RE: 23/02716/DISC Discharge of Condition 5 (Site Development Scheme
of 20/02060/F (Appeal Ref APP/C3105/C/21/3268454
THE STABLES MAIN STREET GREAT BOURTON

.I wish to make the following comments which I consider valid reasons for the refusal of this application.

DRWG. N^o. PBA1

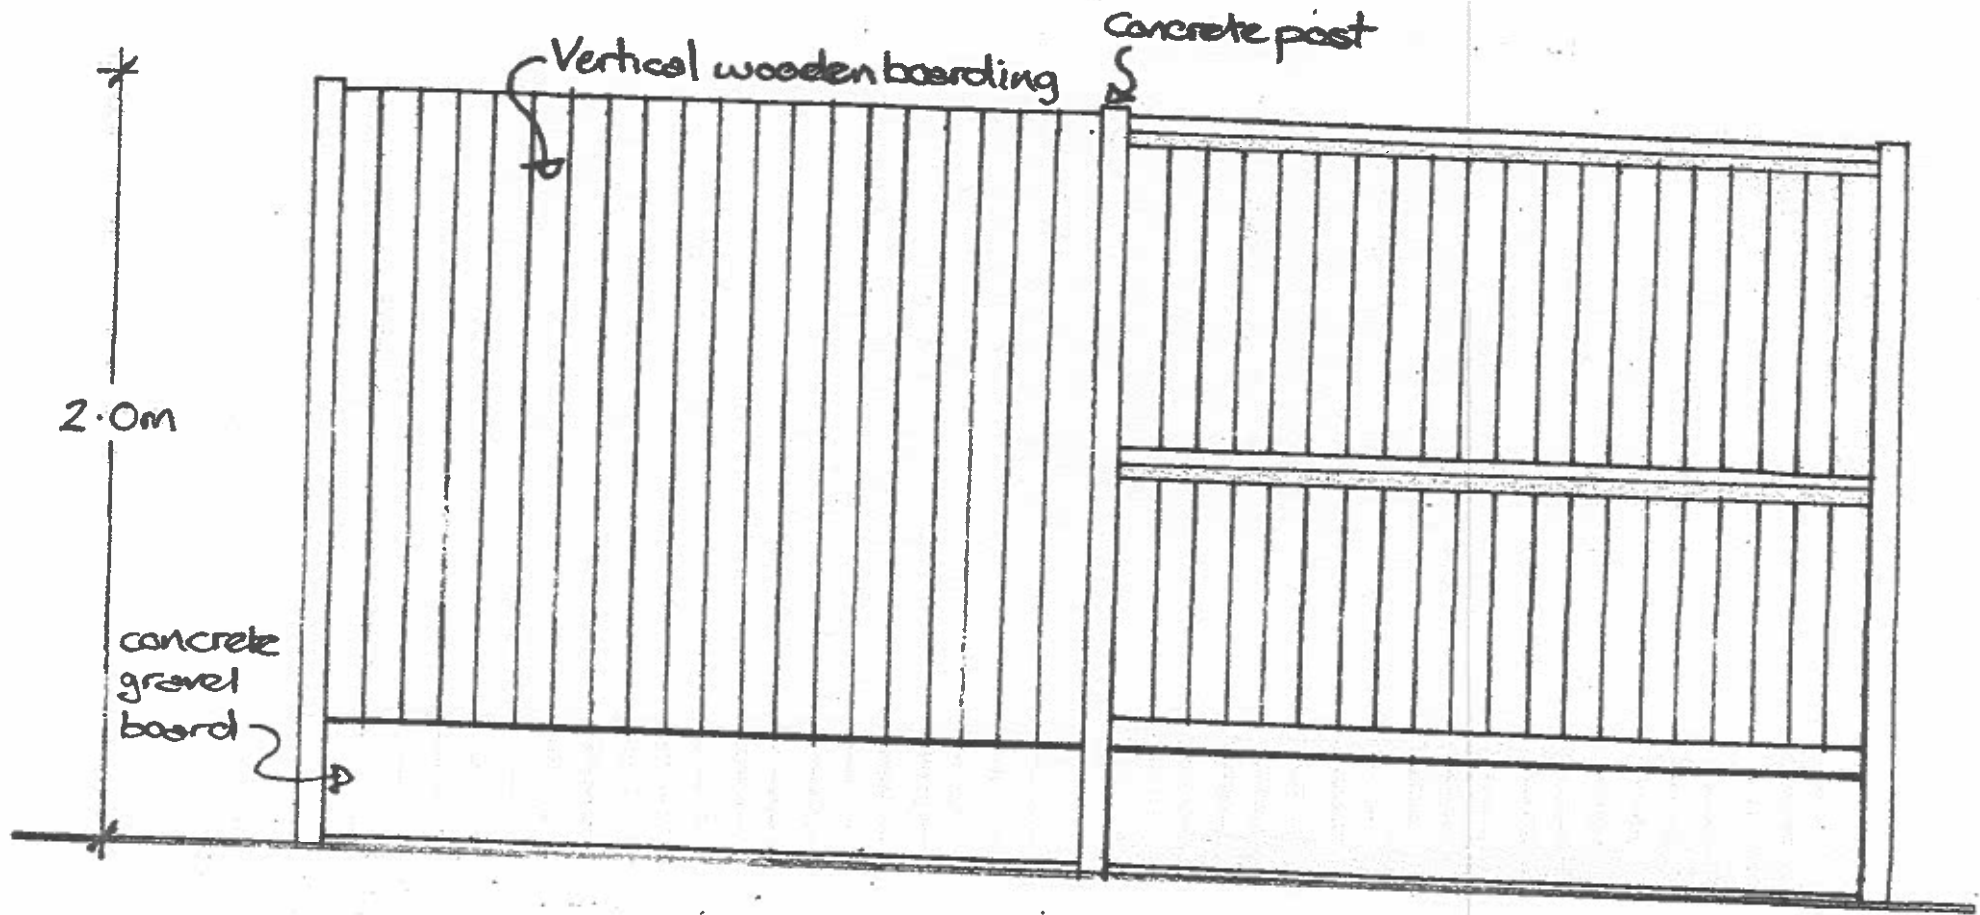
The site plans submitted do not concur and one shows the public footpath as dog legged when in fact it is straight through the corner of the site! The Caravans are shown to be sited on this newly extended and unauthorised hardcore (in exactly the same position as on the previous application which was refused by CDC) and all this hardcore should be removed. The drainage plan showing a swale would not work as it is shown to be situated on land which is already in flood in winter and times of heavy rain because the lower sump land it once drained to is now filled with hardcore. In my younger days I was involved in installing 100 miles annually of farm field land drainage schemes and never would I ever consider filling up the sump land with hardcore knowing full well that through flooding it would be so detrimental to the neighbour's land including the Parish Council owned land the rent from which funds community projects!
